CITY OF ALBUQUERQUE

Re: Unser Substation Grading and Drainage Plan
Engineer's Stamp dated 5-10-06 (G10/D10A)

RE: PNM UNSER SUBSTATION (G10-D10A)

**Re: PNM Unser Substation, 7850 Vista Alegre Street, Site Development Plan
Engineer's Stamp dated 3-20-06 (G10-D10A)**

**UNSER SUBSTATION GRADING AND DRAINAGE PLAN**

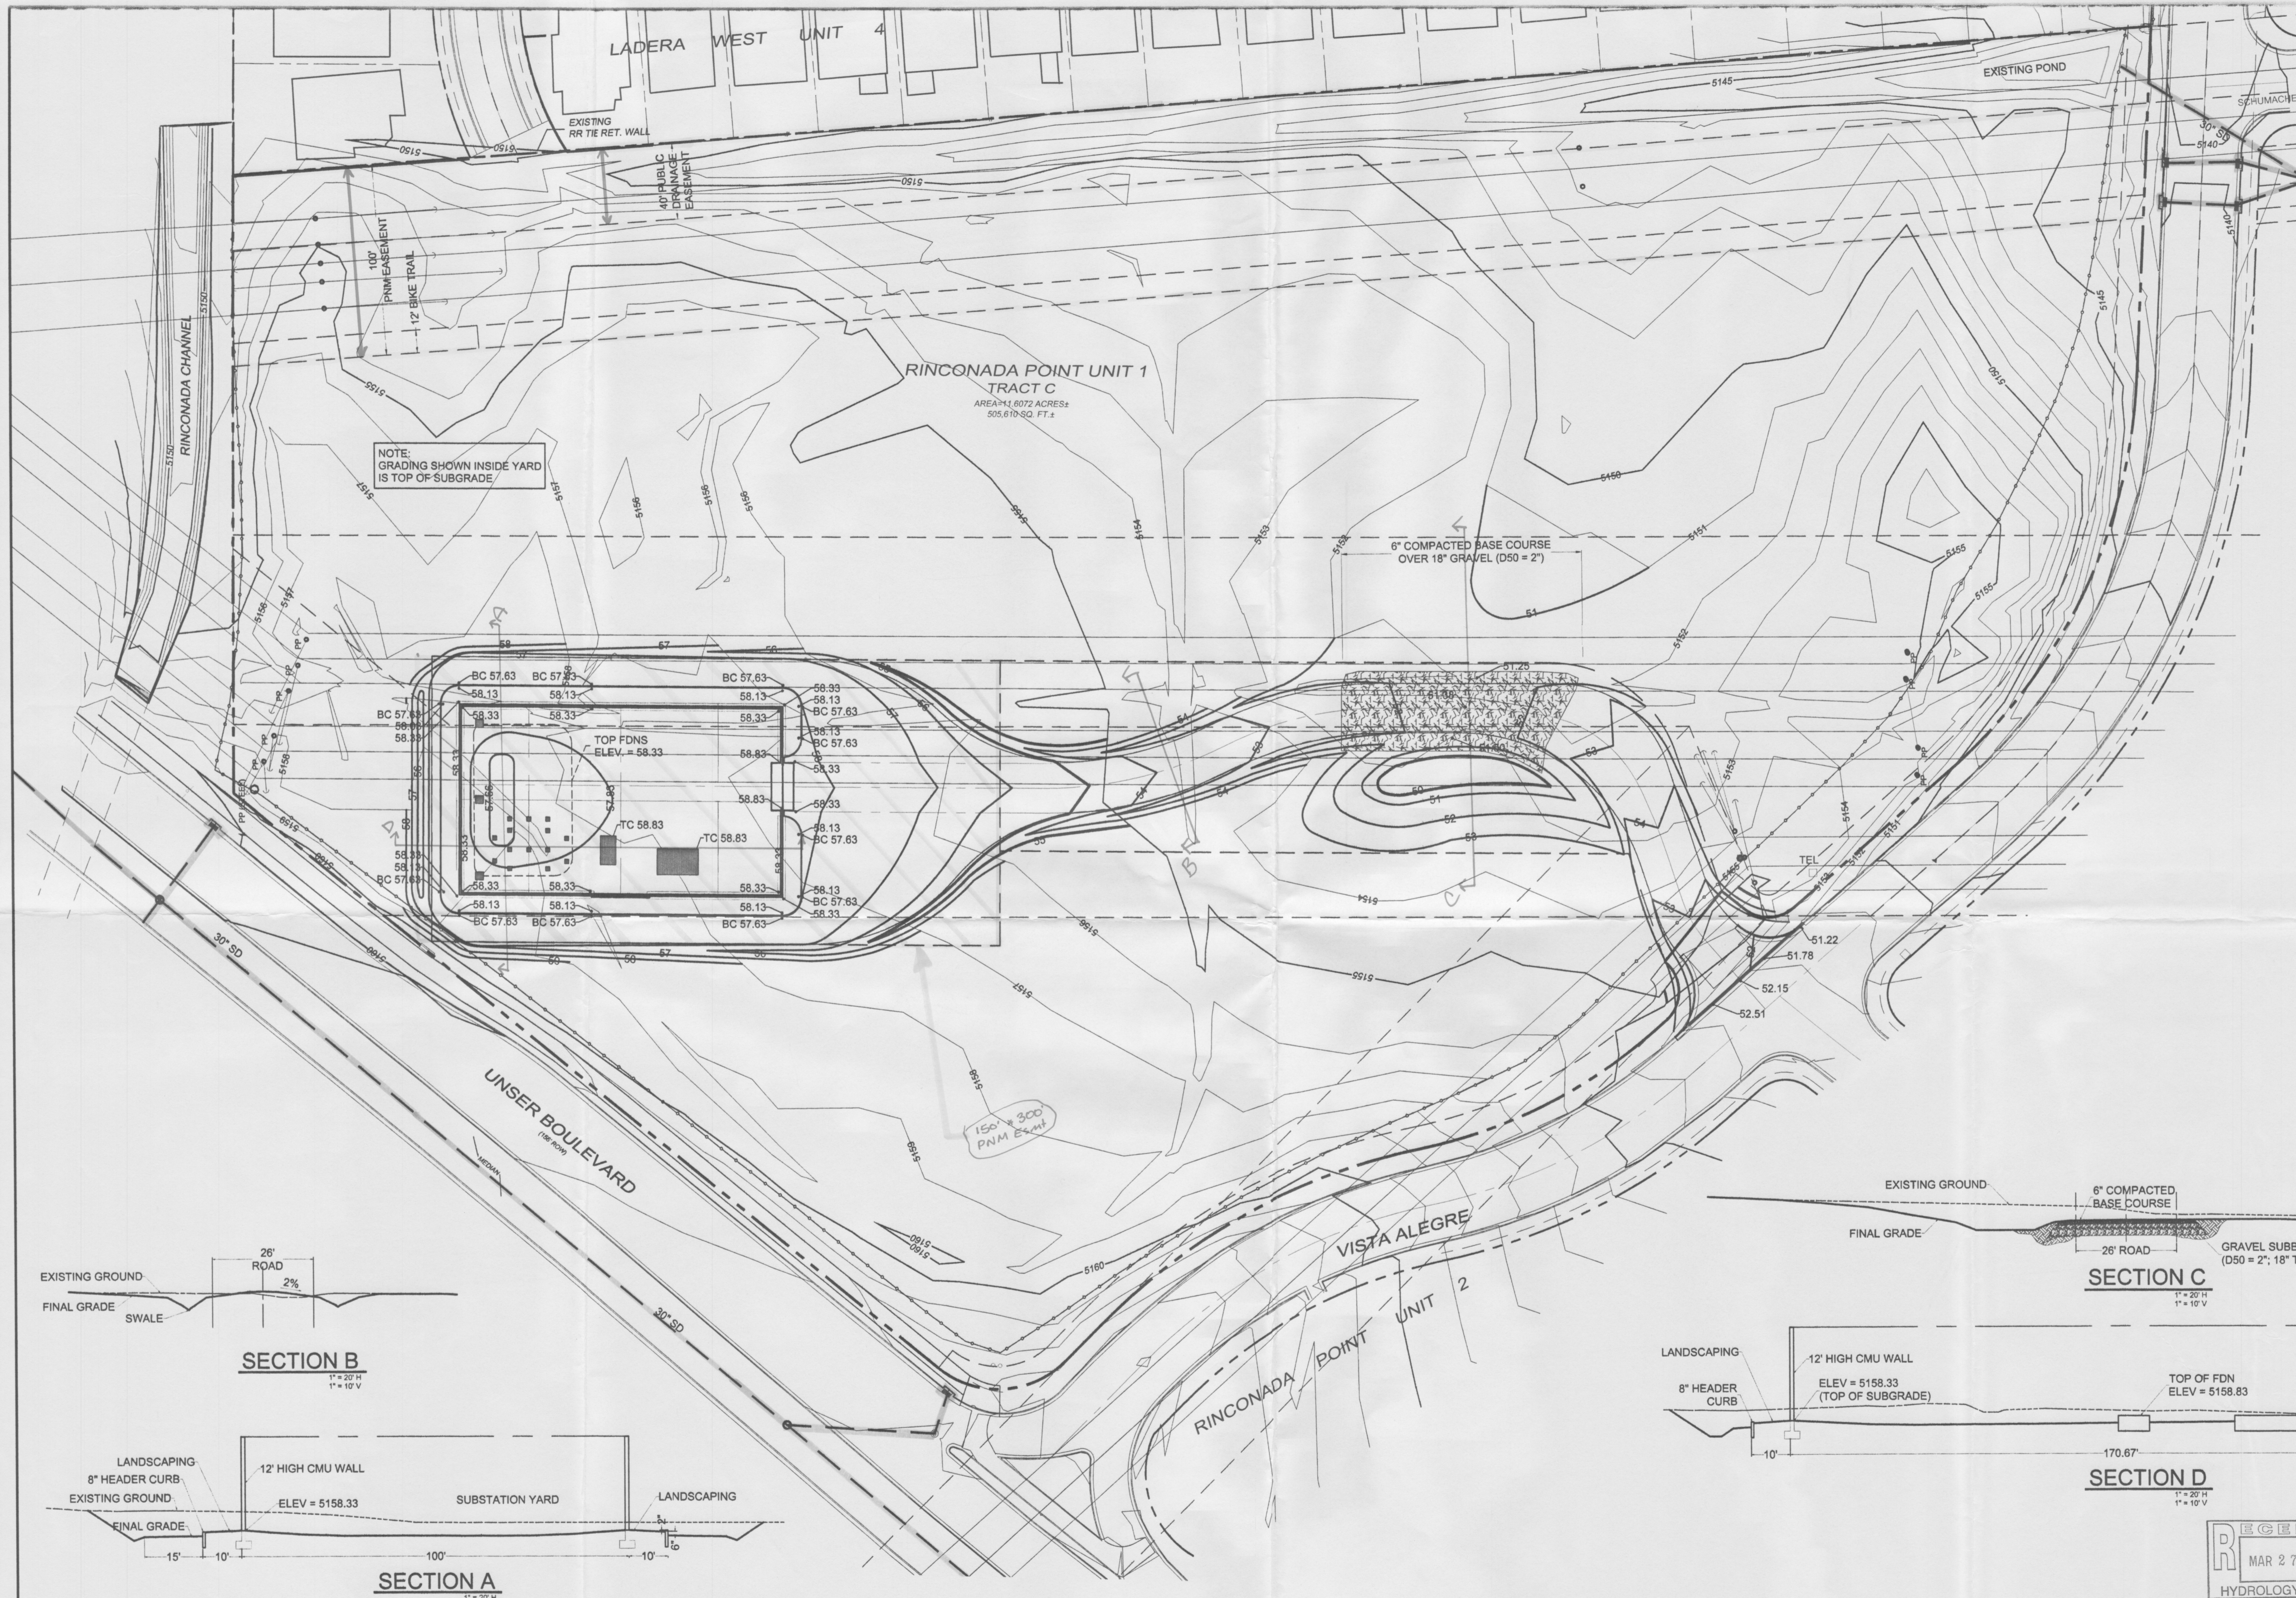
- ✓ 1. A \$100 submittal fee must be paid in full prior to your next submittal.
- ✓ 2. Call out the 150' x 300' PNM easement.
- ✓ 3. What does FDNS mean? FDN? Please update your legend to include these items.

- ✓ 4. Check the plan scale; the easement widths do not scale to their defined lengths.
- ✓ 5. Show the existing swale located along the east property line. This swale is defined in the write up, but not shown on the plan.

- ✓ 6. More detail must be provided for the proposed yard. The write up says the site runoff will stay within the yard; how will this be done? You propose (within the write up) small depressions, or ponds, to be placed within the yard. What is the purpose of these ponds? Water harvesting for landscaping? Please provide more information.

7. Clearly define the quantity of flow that drains to the existing pond. Where does the rest of the flow drain?
8. Provide geometric detail for the existing pond. What will the proposed site improvements do to the flow entering the existing pond? If the pond outfall is currently blocked, you will need to rectify this situation with this project.

1. We expect to pay the fee if required with this submittal.
2. The 150' x 300' PNM easement has been dimensioned on the plan.
3. The abbreviations "FDNS" refers to the proposed ground-level concrete foundations to be located within the substation yard. The legend reference on the drawing has been clarified.

4. The plan scale has been adjusted to ensure that the drawing scales as labeled.
5. The drawing has been modified to label the existing swale along the east property line of the tract. This swale is otherwise only evident in the field and by the shape of the contours. It apparently is not naturally-occurring but was constructed, presumably according to some plan that has not been discovered.

6. The substation electrical equipment will be contained in a yard enclosed by a 12' high CMU wall, with openings only for gates. The drainage intent of the yard grading is that the yard be isolated from all runoff and runoff - all precipitation falling within the yard will remain within the yard. To accomplish this, the yard area within the wall is to be graded and graveled with a slight slope downward to a depression in the north end of the yard which will serve as a retention pond. The wall openings for gates are fitted with concrete aprons that are elevated high enough relative to both the yard and the surrounding site grading that they prevent stormwater runoff from either entering or leaving the yard. While the volume of runoff retained within the yard is not great, this internal retention pond is also necessary as the grading component of PNM's standard system of secondary containment guarding against the effects of equipment failure. The grading plan therefore shows the spot elevations and proposed grading contours necessary to construct this solution. The narrative in the plan has been revised to clarify this intent.

corner of the property. For drainage analysis purposes, the entire property has been divided into its relevant drainage basins. The project hydrology shown on the plan reflects the impact this project has on each of these basins. The plan has been revised to add flow direction arrows to clarify the general direction of flow within each of the respective basins and respective outfalls. As with the existing swale, the only evidence of a pond on site is the shape of the contours and a slight depression at the downstream end of the swale. The hydrology calculations of the plan report the volume of runoff expected to reach this pond under both present conditions and under otherwise present conditions after the construction of the substation project. The narrative in the plan has been revised to clarify that the difference this substation project makes with respect to runoff in the direction of the pond is an increase of about 1550 cubic feet. It would appear the original intent of the pond was to retain runoff until such time as the storm sewer system in Vista Alegre was constructed. According to as-built drawings for construction of Rinconada Point Unit 2 Subdivision, an outfall from this pond was called for to drain it to a new storm sewer system in Vista Alegre. However, no details for this outfall were provided in the plans, and the drawing making reference to this outfall pipe is not much better than schematic. The substation will occupy an easement within the presently undeveloped 11.6-acre tract. As the owner of the tract, the City will determine the ultimate development of the property. With a closed-conduit storm sewer system, including drop inlets, in the street immediately adjacent to the tract, it is unlikely that the pond will be a necessary component of any ultimate drainage solution for the property.

8. There are no design criteria and details available for this pond. The only geometric reference we have is the shape of the contours. In the field, it is evident that a pond must have been constructed, but has deteriorated and lost its original shape over the years. This pond, and the swale that drains into it, are within a City drainage easement on a City-owned tract of land. As a City pond, its condition and outfall are properly the maintenance responsibility of the City. If there ever was a piped outfall from this pond, it is not visible in the field, is likely obstructed, and is not functional. In either case, the outfall from this tract by overflow of the pond or by its piped discharge is received by the storm sewer system in Vista Alegre. The substation project does not propose anything that will change this pattern, and adds only minimally to the present outfall conditions. Attached is a photograph of the pond to illustrate its condition.
